Your Ref: 2023/93083
Our Ref: Z005264

adj 33 Arthur Street, Golcar, Huddersfield – Demolition of detached garage and erection of 1 detached dwelling, formation of car parking spaces and access, associated landscaping, reconfiguration of parking spaces and access for existing dwelling

2. The details submitted on drawing, Plans as proposed (22137)2 dated September 2023 prepared by JG-d Architecture and Design requires amendments. The following point should be addressed:

Block Plan 1: 200

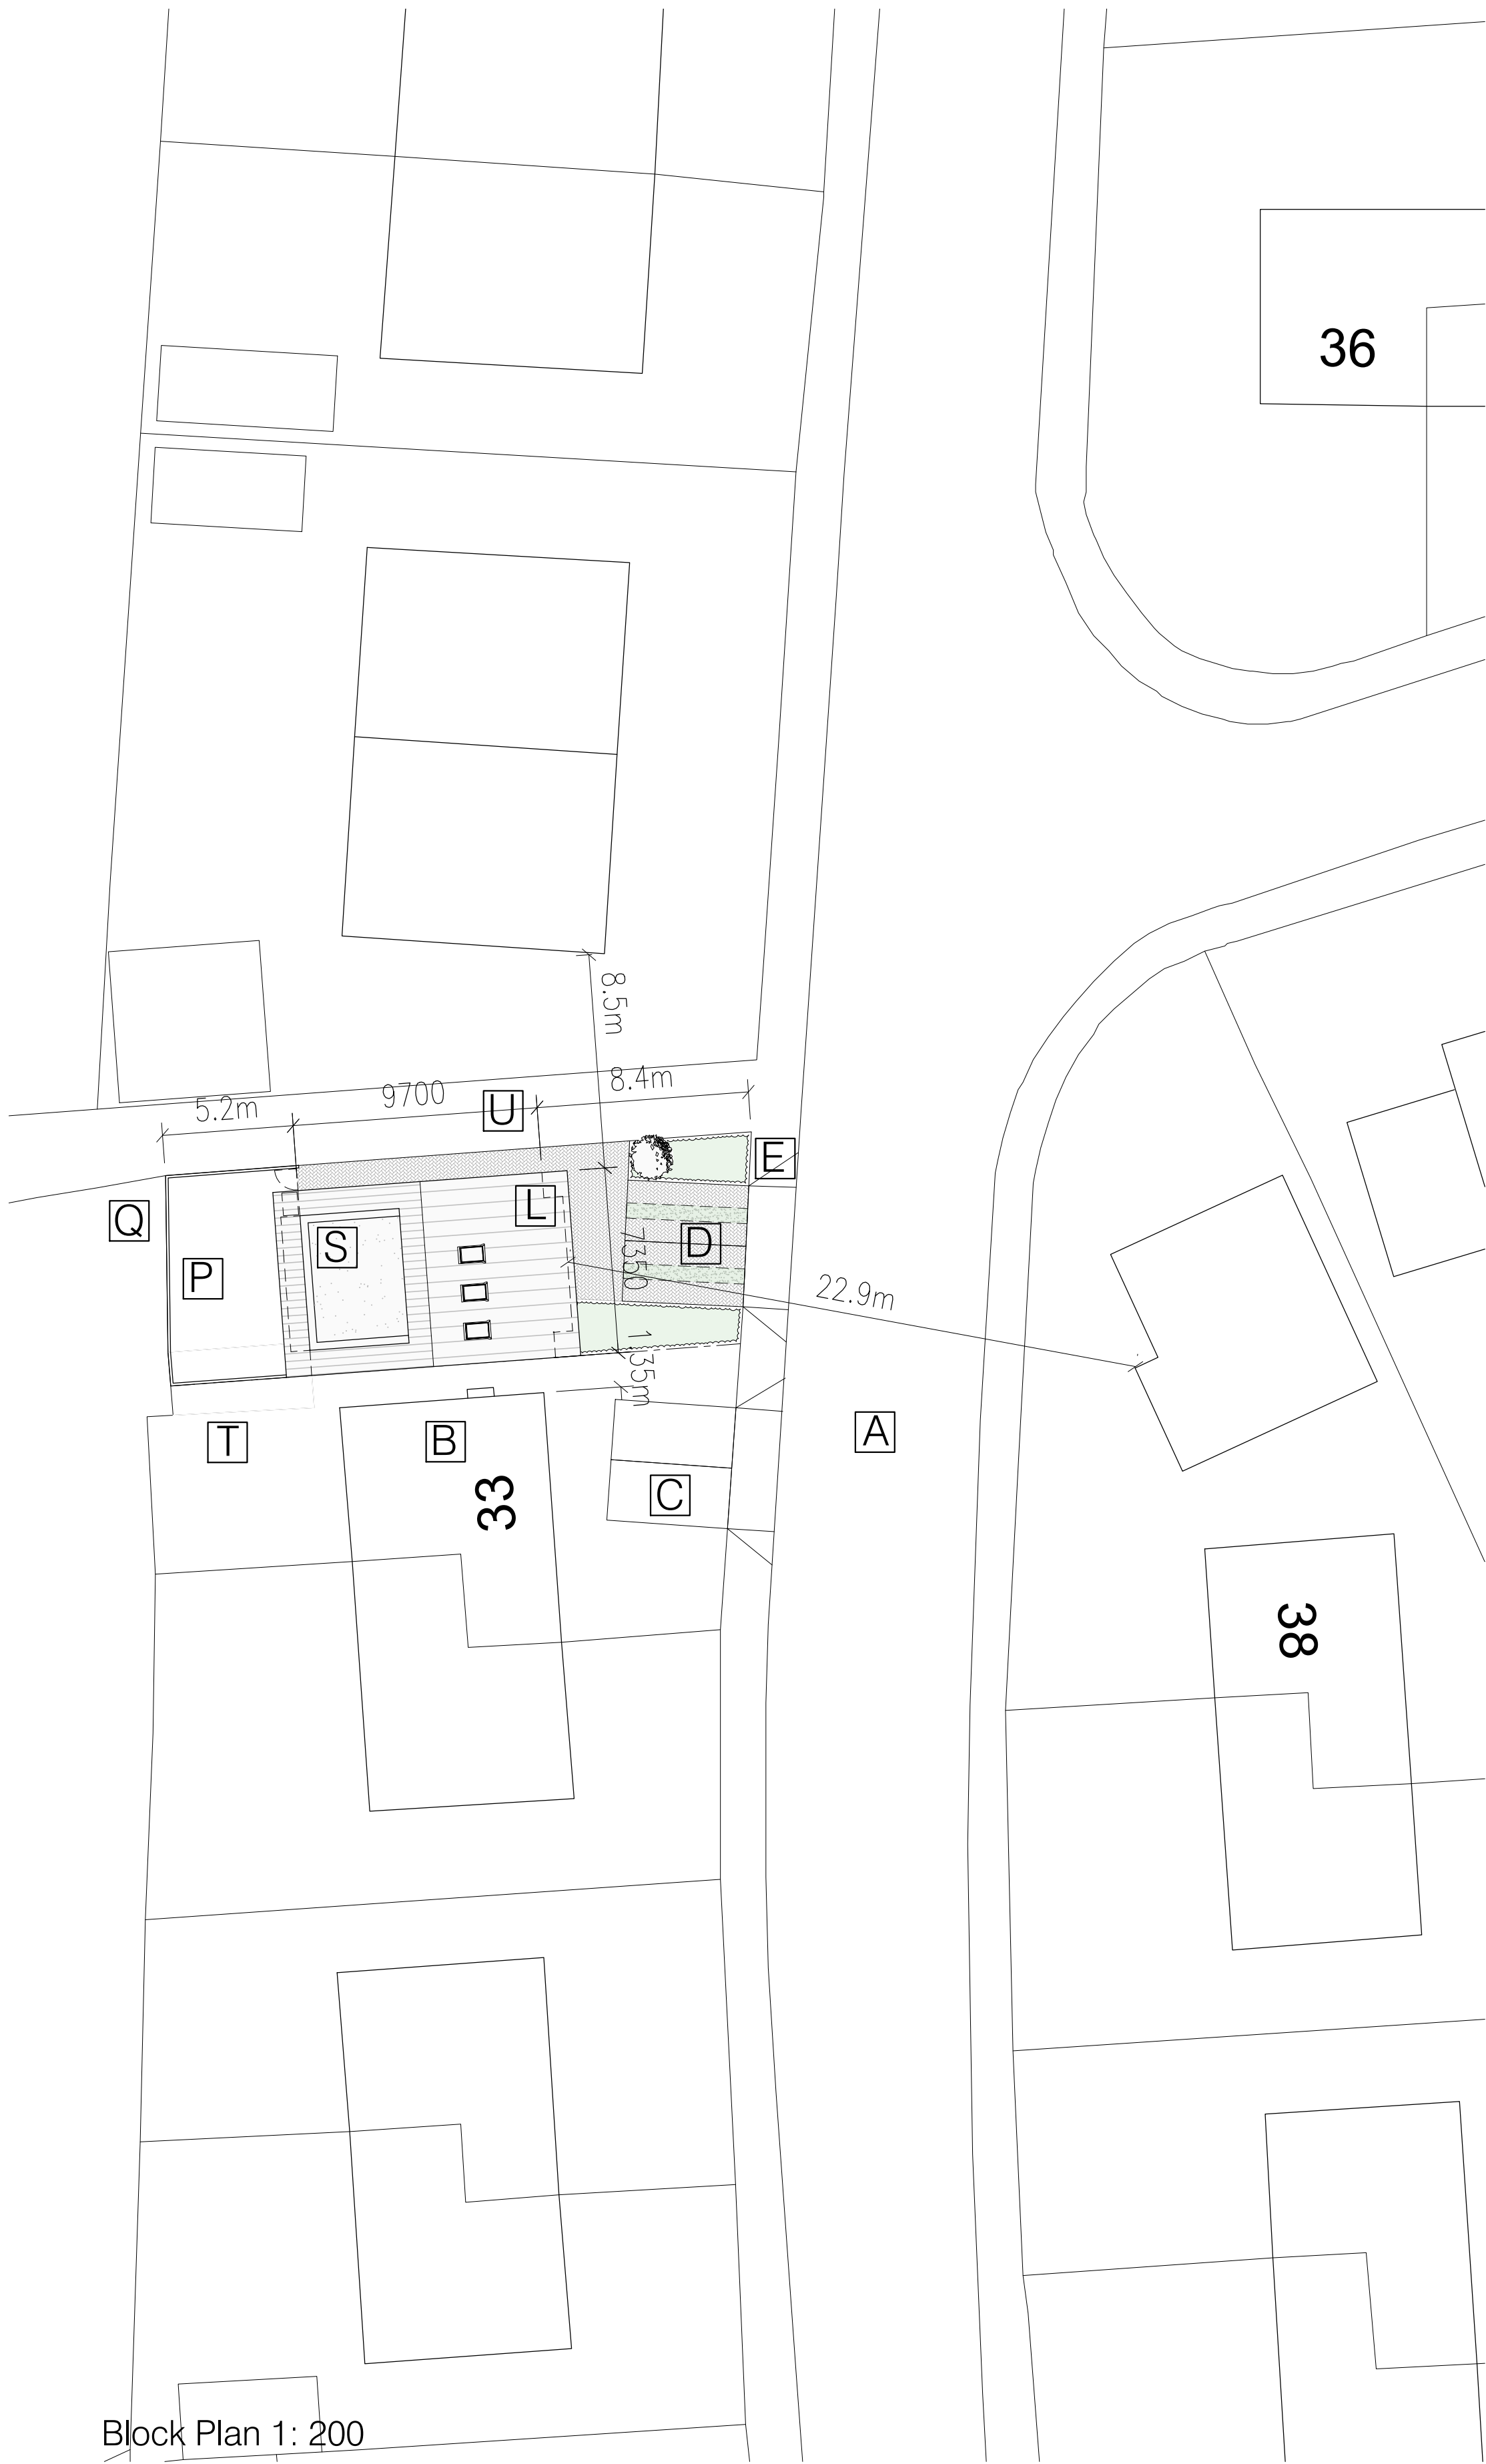
It appears from the submitted site layout that tree/s will be sited over the public sewerage system located within the site. This could seriously jeopardise Yorkshire Water's ability to maintain the public sewerage network and is not acceptable. We therefore **OBJECT** to the development layout as currently shown. I strongly advise that, prior to determination of this application, the site layout is amended to allow for adequate protection of the sewers. For further information, the developer should contact our Developer Services Team: telephone 0345 120 84 82 (option 1) or email technical.sewerage@yorkshirewater.co.uk.

i) the submitted drawing appears to show a tree directly over the line of the public sewer crossing the site which is not permitted. The submitted drawing should show the required stand-off from public sewer or an alternative scheme.
